**DEXUS QUARRYWEST PROJECT (SSD 6801) – SECTION 4.55 MODIFICATION (MOD 8) –
RESPONSE TO SUBMISSIONS**

FIRE ENGINEERING STATEMENT

**DEXUS QUARRY WEST LOT E– SSD 6801 MOD 8 - WAREHOUSE E3 AND E4, PROSPECT HIGHWAY
PEMULWUY**

Developable Lot E Plan

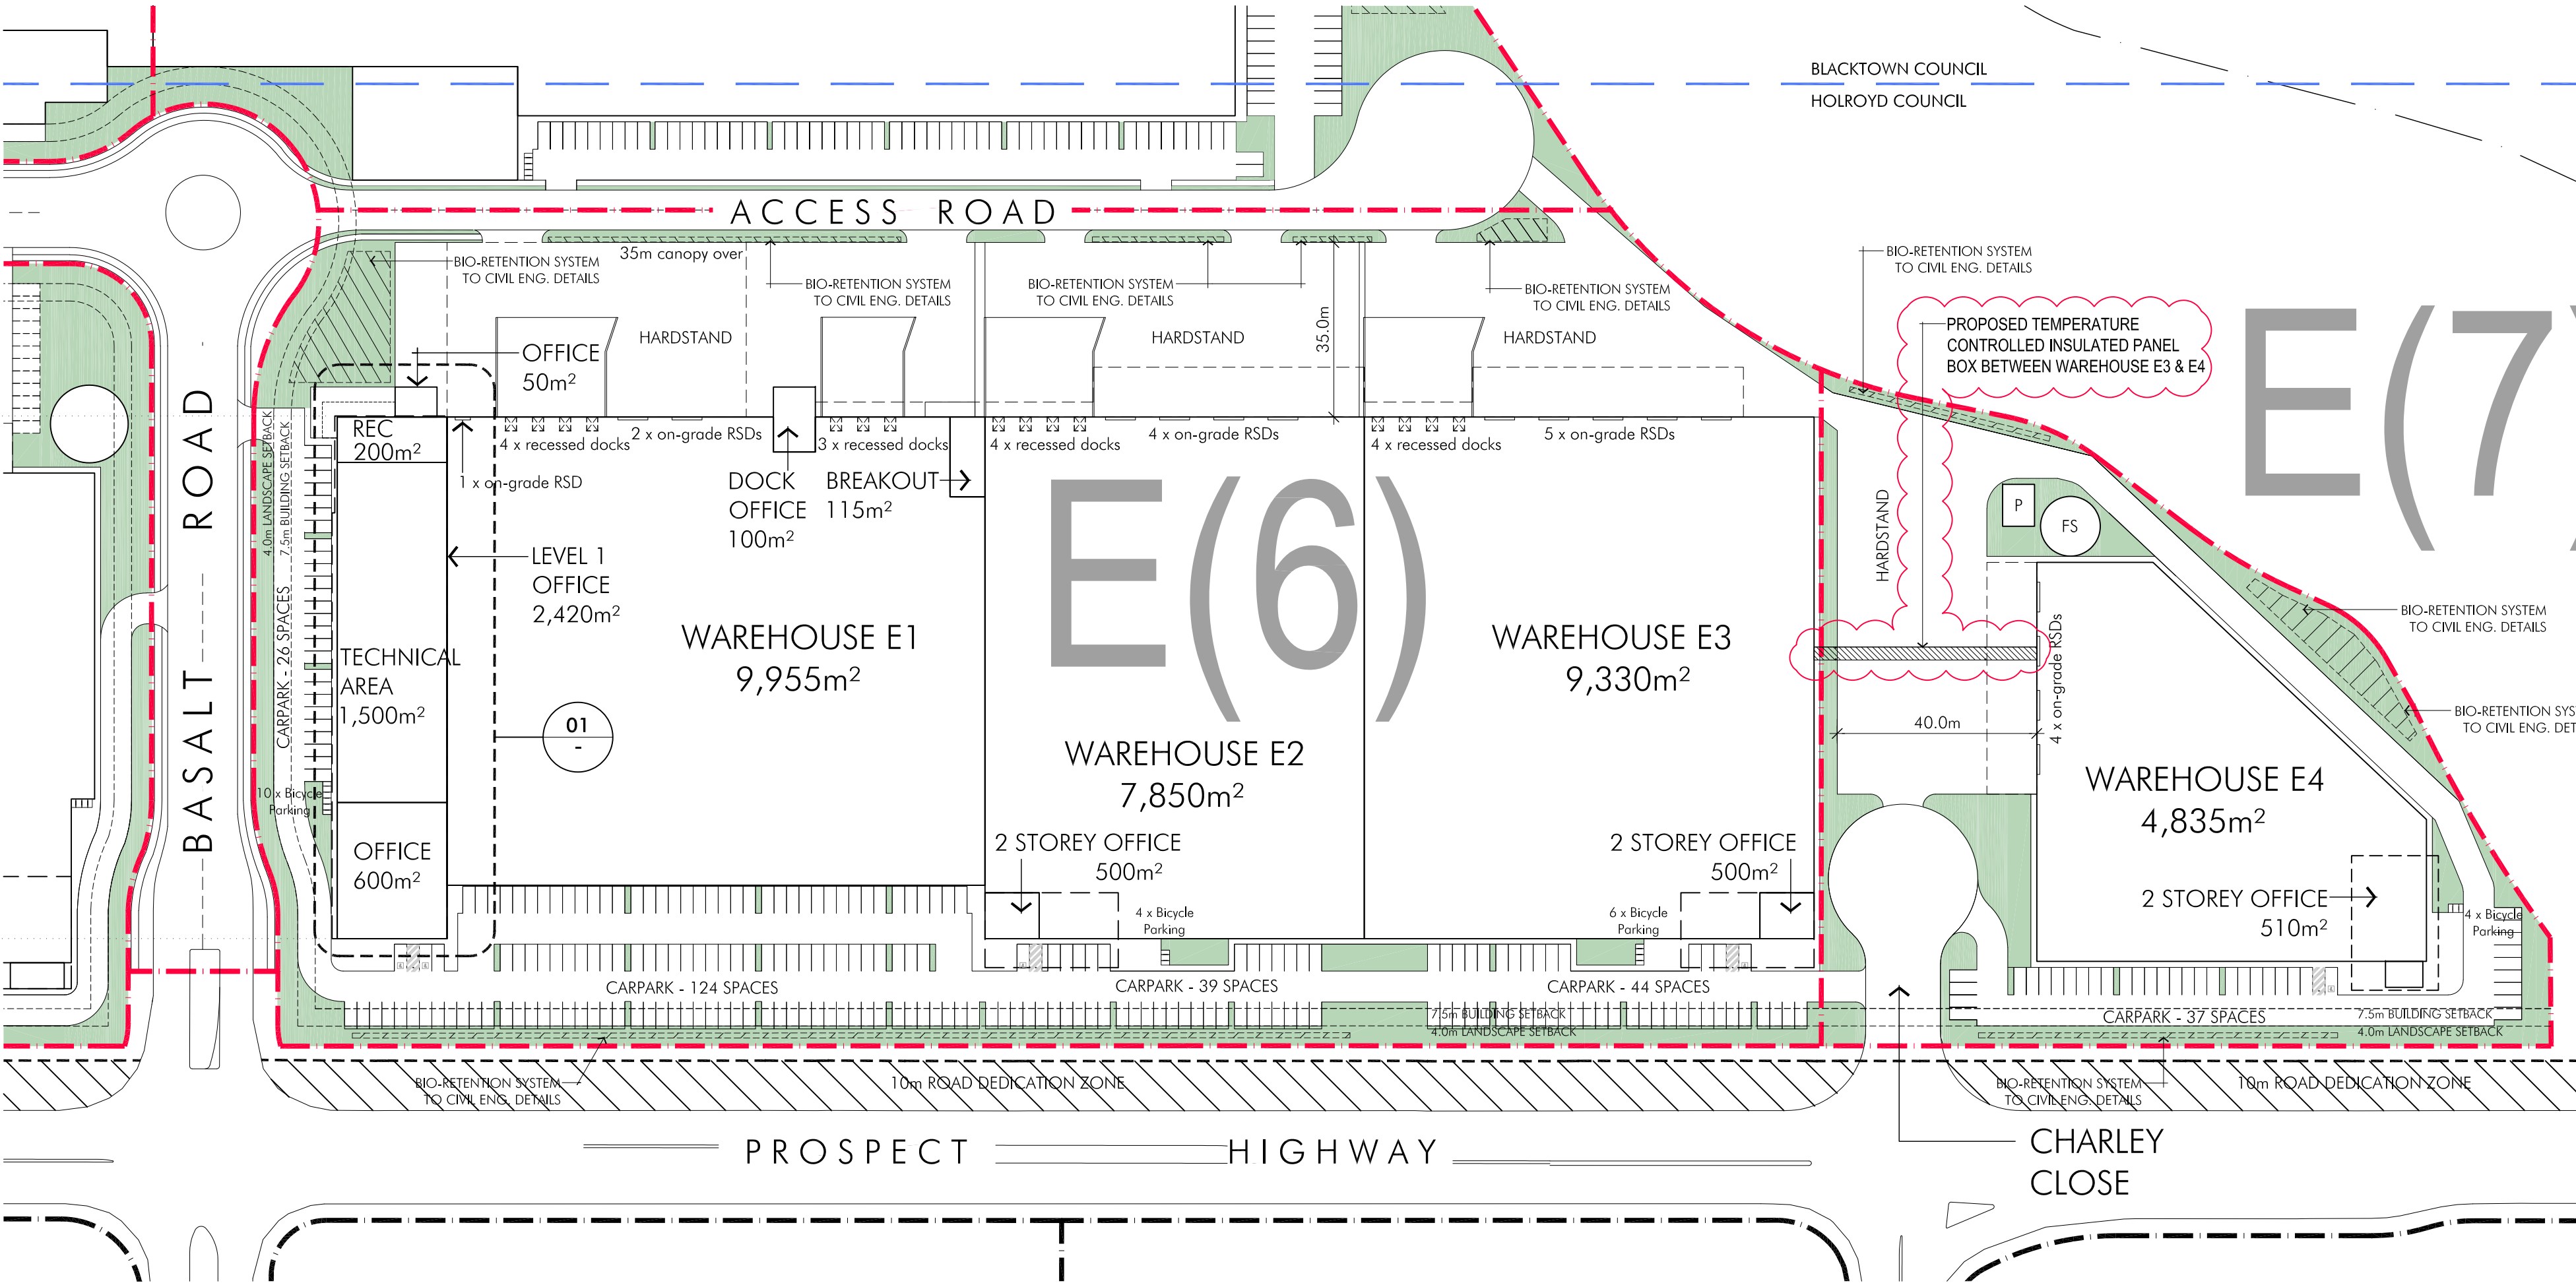
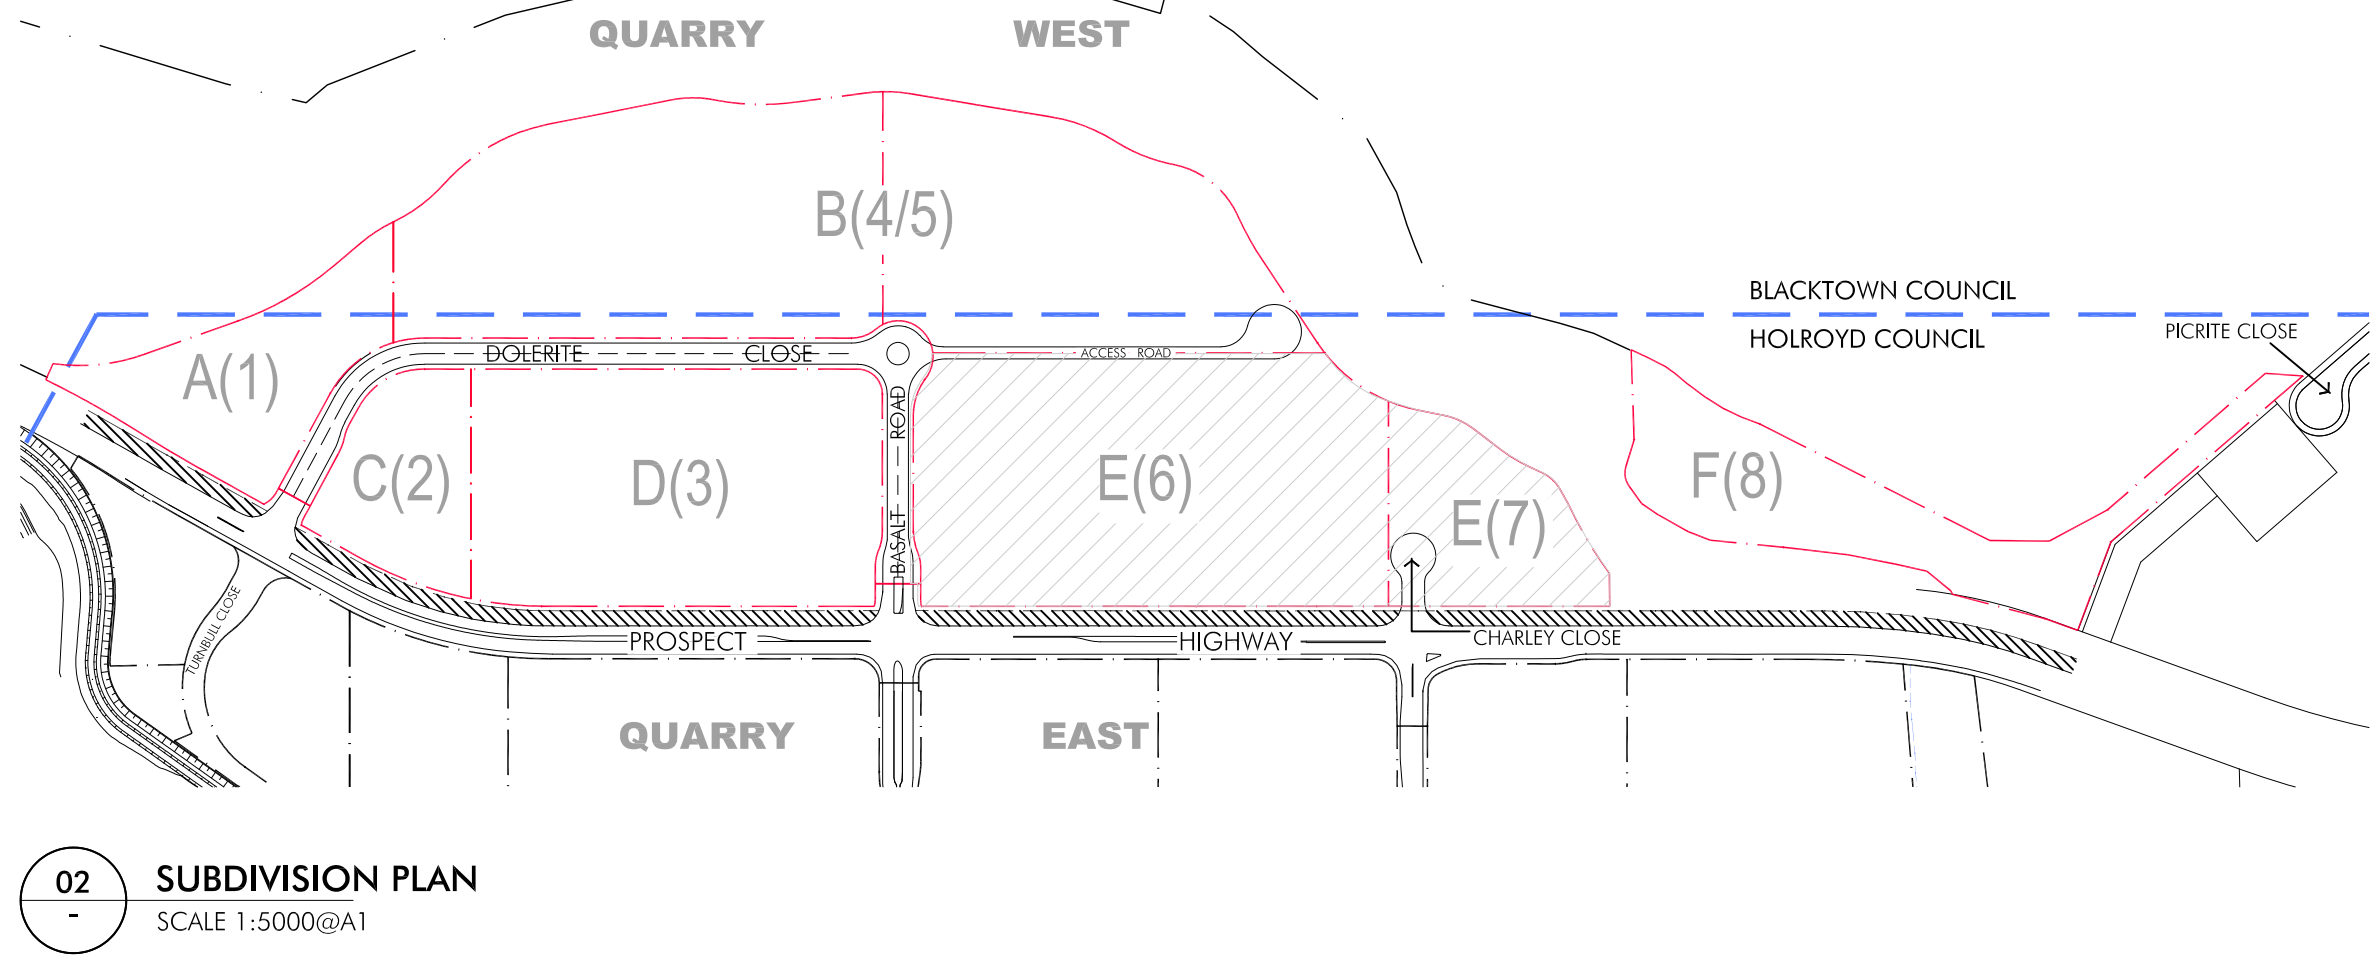
- 1. Consideration be given to the impact that the new conveyor structure including supporting columns will have on the requirements for emergency vehicle access between the warehouses.***

Whilst the conveyor passes over the roadway currently relied upon for access to Warehouse E3 and E4 a Performance Solution can demonstrate compliance with CP9 subject to consultation with FRNSW during design development. The fire safety strategy will rely upon:

- The conveyor structure is independent to that of the warehouses, with physical protection provided to the columns to protect them from impact damage; and
- There is redundancy in the design as alternative pathways that circumnavigate the remainder of the building are available (refer to the shaded area in **Figure 1**); and

- The clear height to the underside of the conveyor exceeds the 4.5 m required under Clause 5.5 of FRNSW's Policy No.4 (Guidelines for Emergency Vehicle Access); and
- If Warehouse E3 and Warehouse E4 were to be considered as a united building under the BCA there is no DTS non-conformance.
